**VOLLMER ROAD (NORTH)
ROADWAY PLAN & PROFILE**

SHEET 3 OF 17
 JOB NO. 25188.00

BY	DATE								
BY	DATE										
<b>VOLLMER ROAD (NORTH)</b> <b>ROADWAY PLAN &amp; PROFILE</b>											
SHEET 4 OF 17 JOB NO. 25188.00

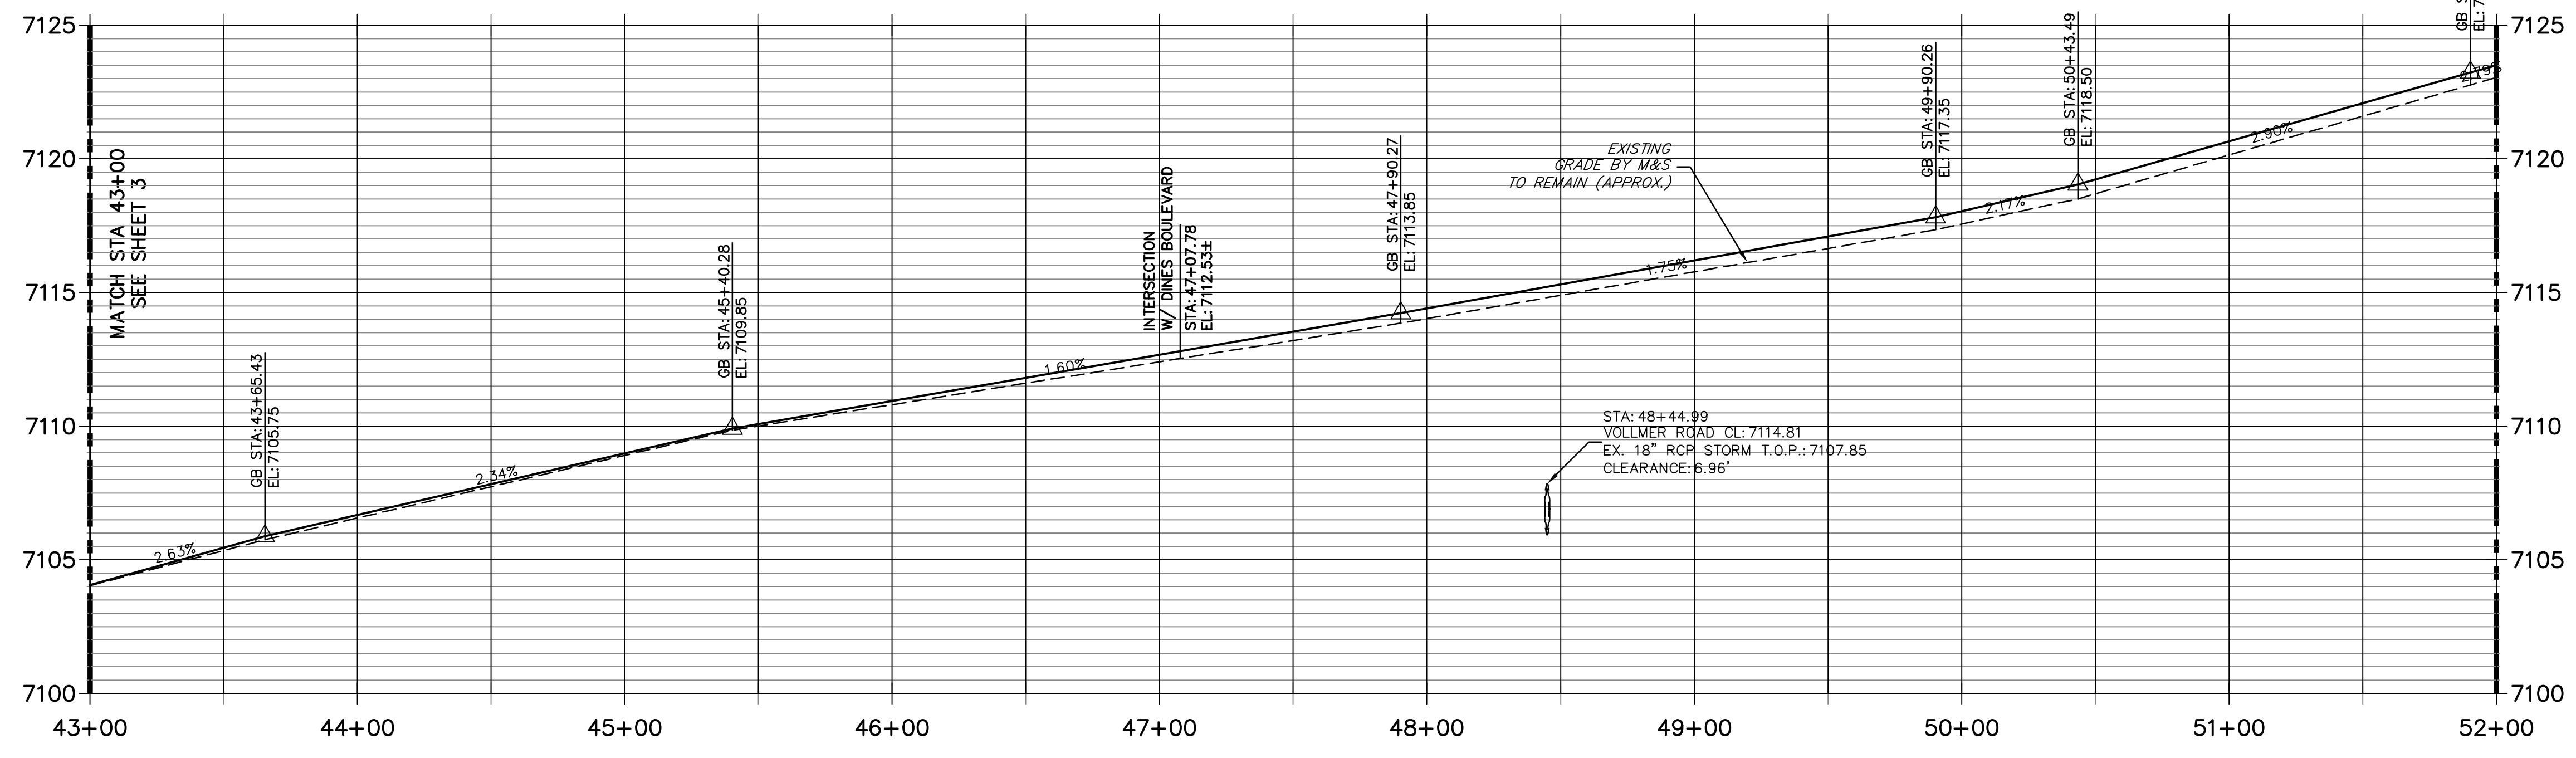
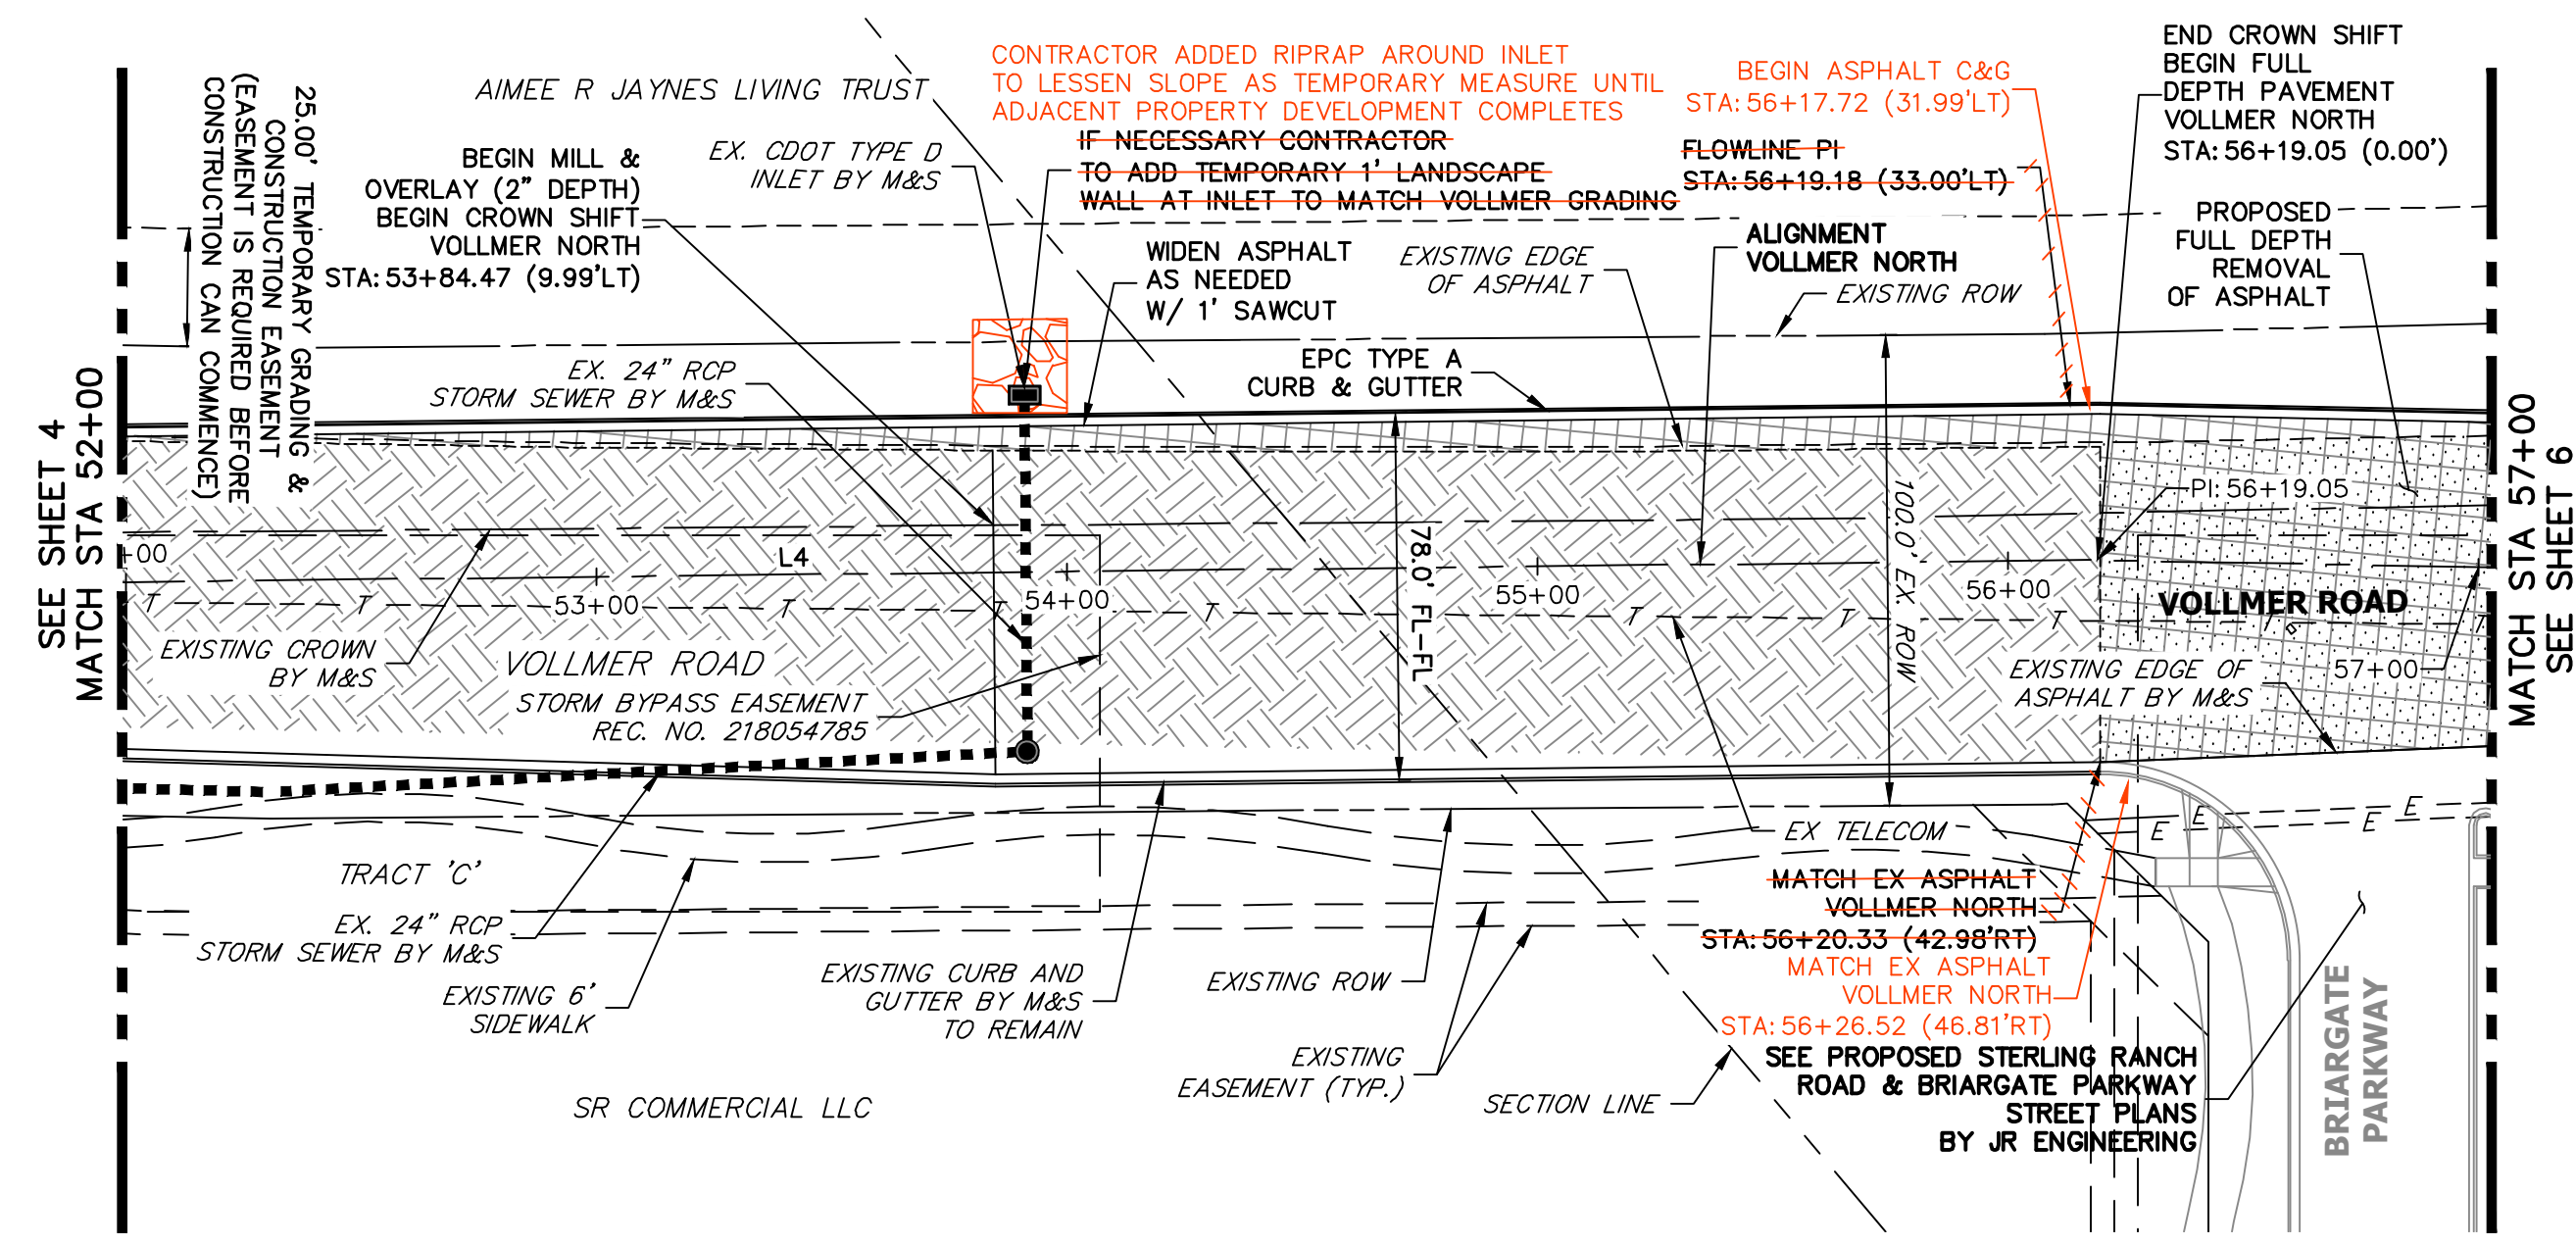
Unresolved Review 1 and 2 comment.
 Review 3 comment:
 The developer/contractor flow filled this pipe with slurry recently on 4/24. Please update this note to be accurate
